EL PASO COUNTY GRADING AND EROSION CONTROL PLAN CHECKLIST

EPC Project Number: CDR2312

<b>TRAILS AT ASPEN RIDGE - STOCKPILE</b>			
CONSTRUCTION DRAWINGS GRADING AND EROSION CONTROL PLANS			
<b>GRADING AND EROSION CONTROL PLAN</b>			
DESIGNED BY:	NMS	SCALE	DATE ISSUED: MAY 2023
DRAWN BY:	TRS	HORIZ N/A	DRAWING No. GEC01
CHECKED BY:	NMS	VERT. N/A	SHEET 3 OF 8

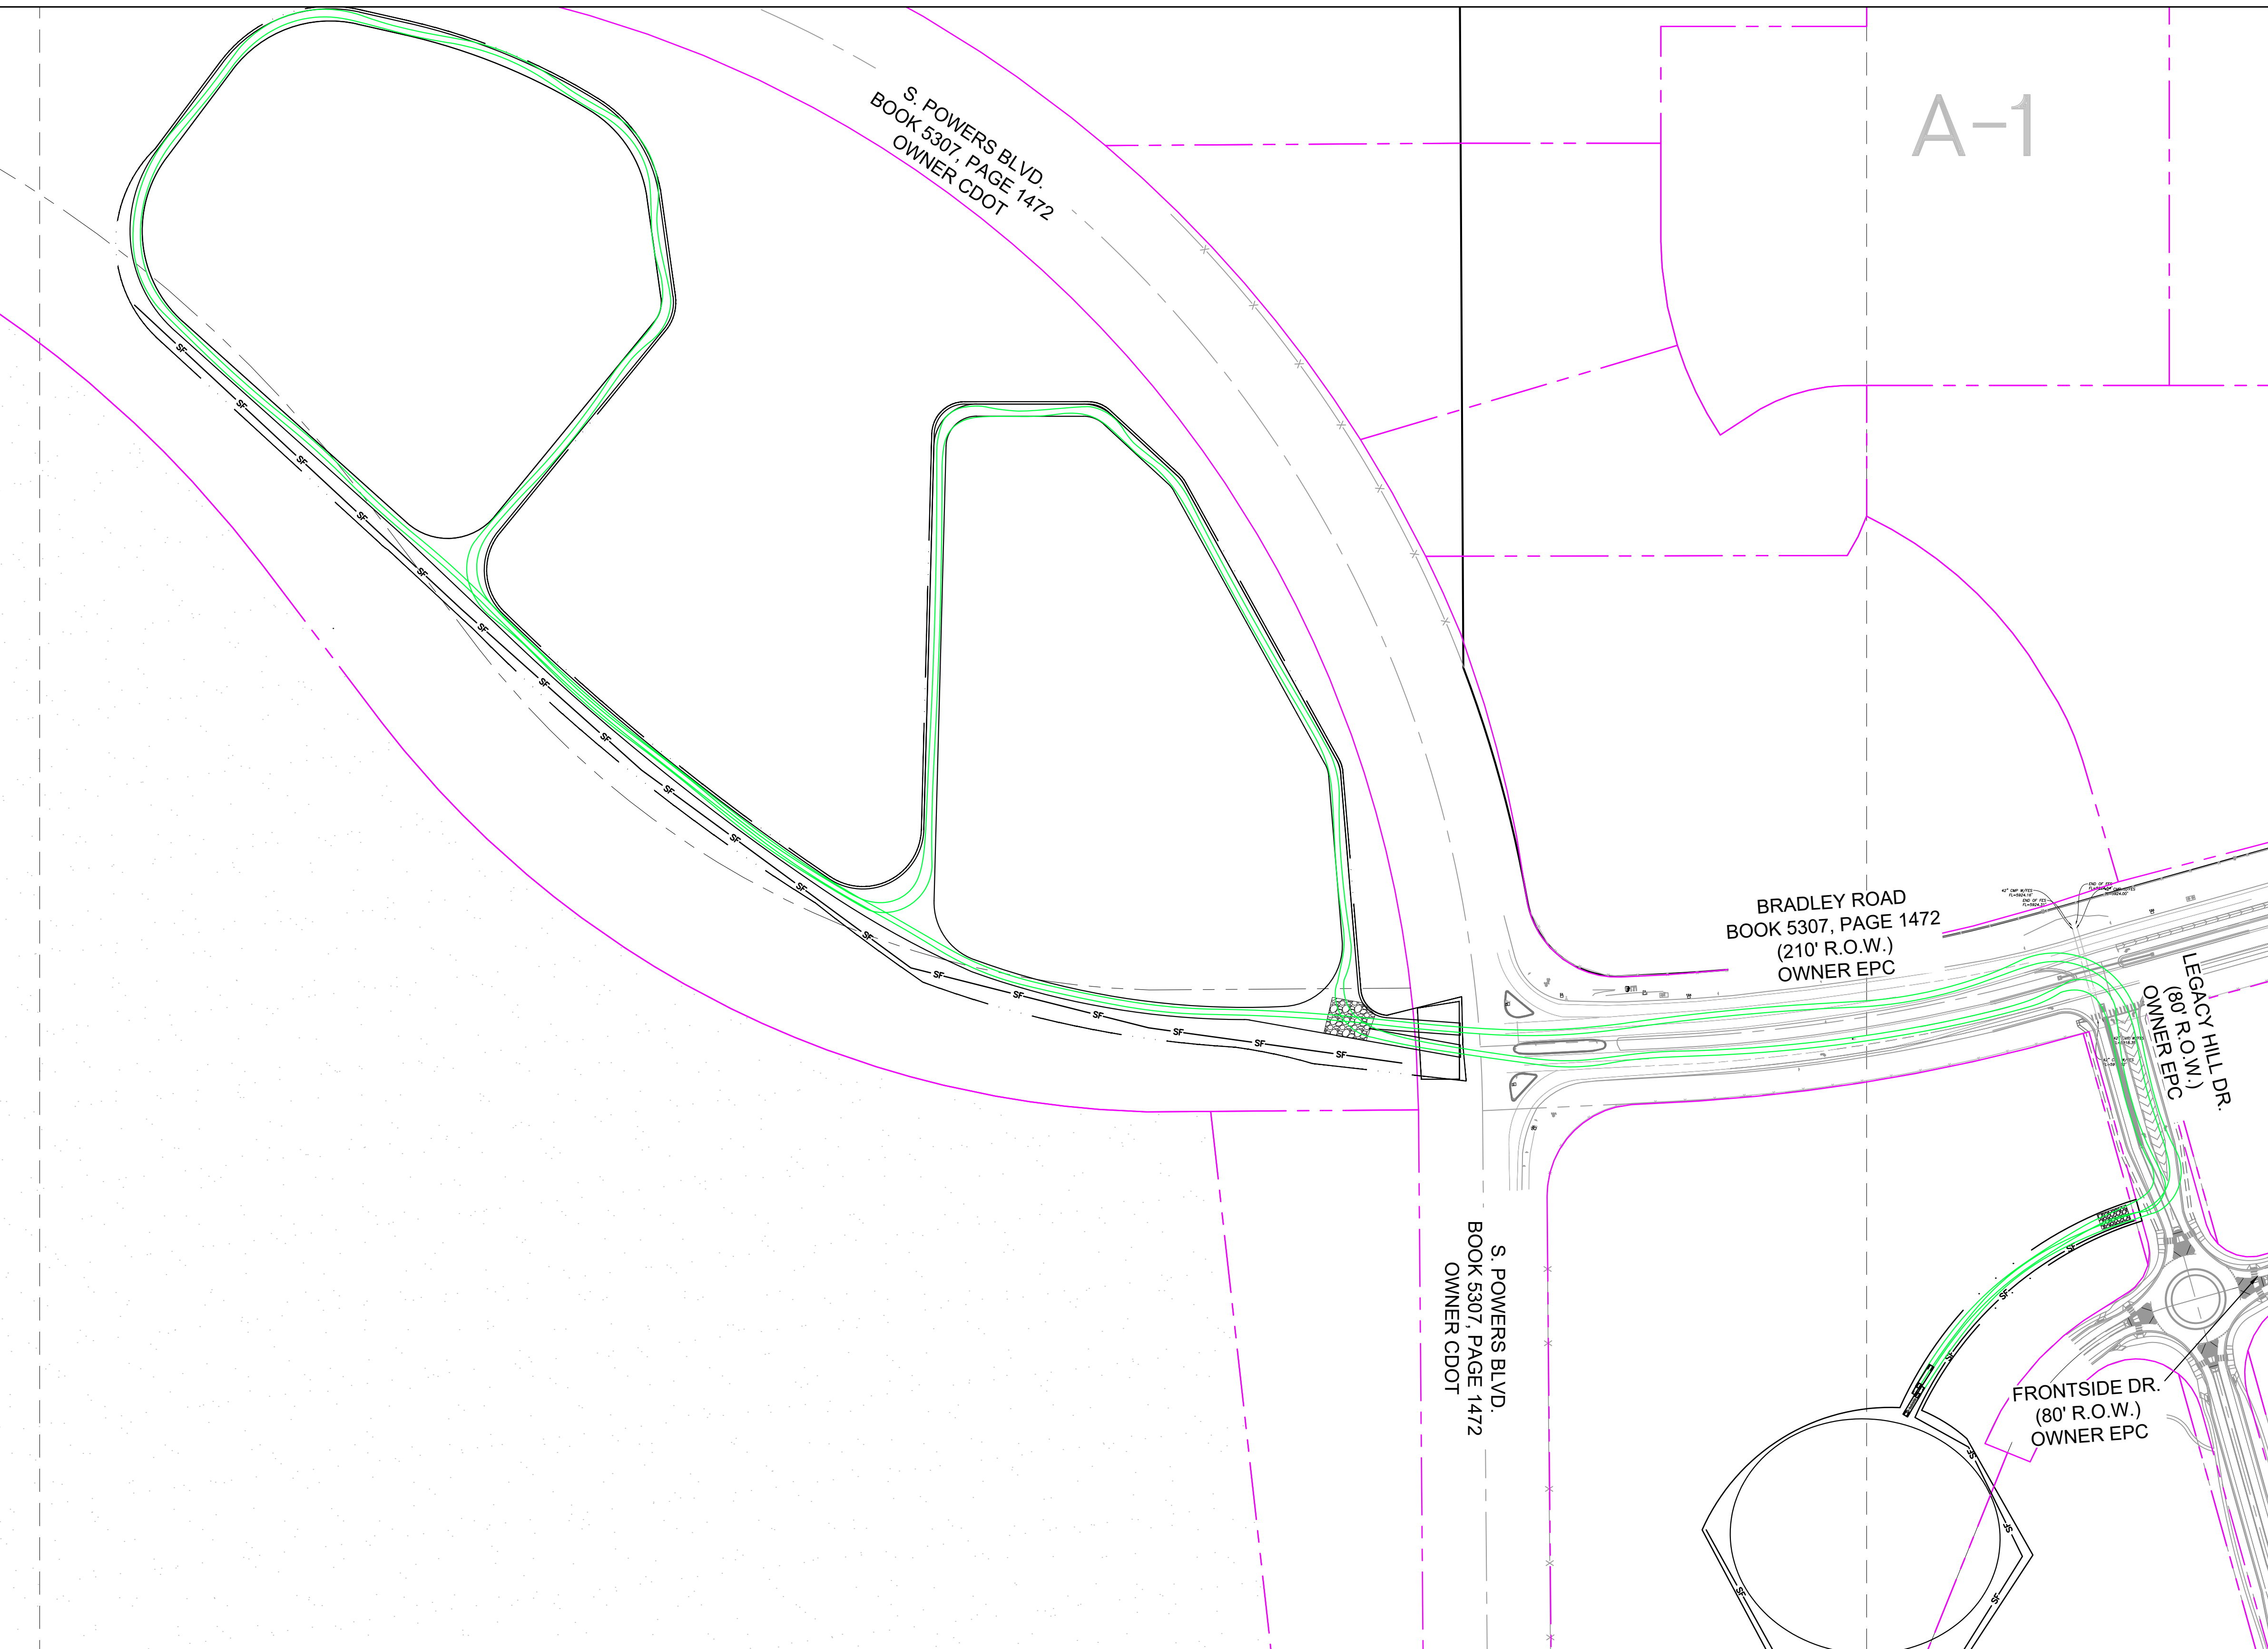
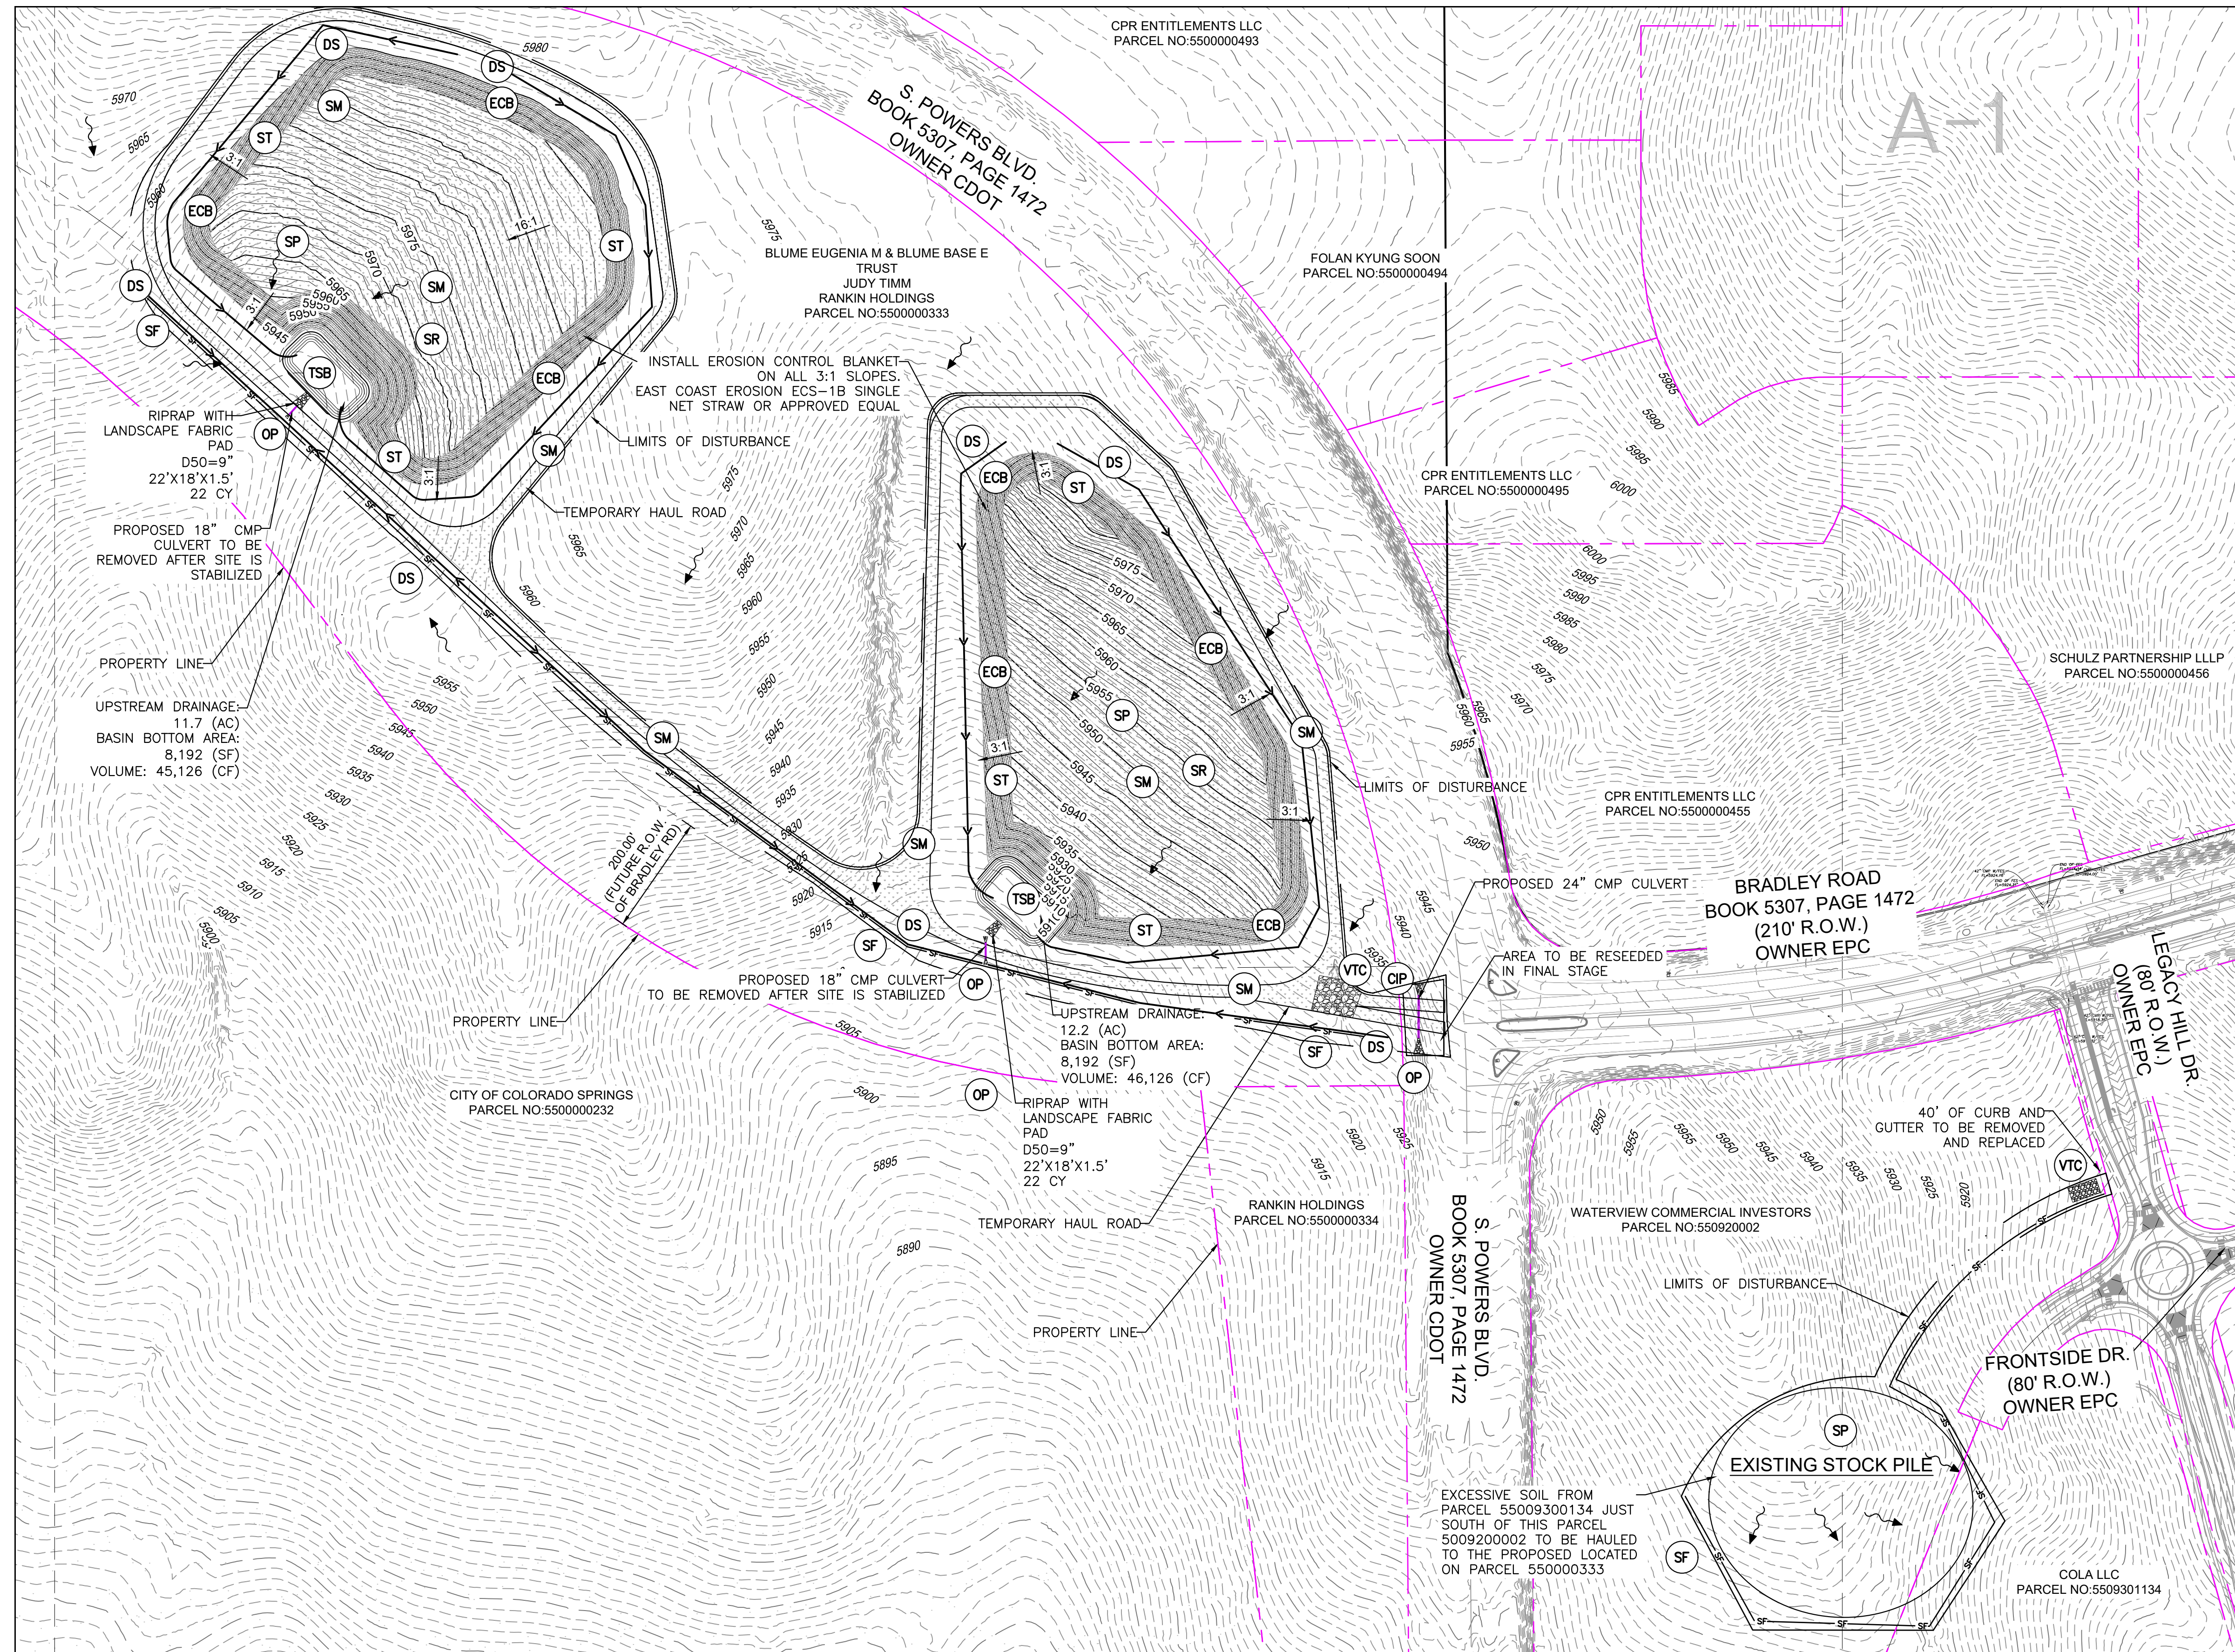
v	All proposed temporary construction control measures, structural and non-structural. Temporary construction control measures shall be identified by phase of implementation to include "initial," "interim," and "final" or shown on separate phased maps identifying each phase		N
w	Vehicle tracking provided at all construction entrances/exits. Construction fencing, barricades, and/or signage provided at access points not to be used for construction		Y
x	Temporary sediment ponds provided for disturbed drainage areas greater than 1 acre		N

See comment on Sht 3 of GEC Plans
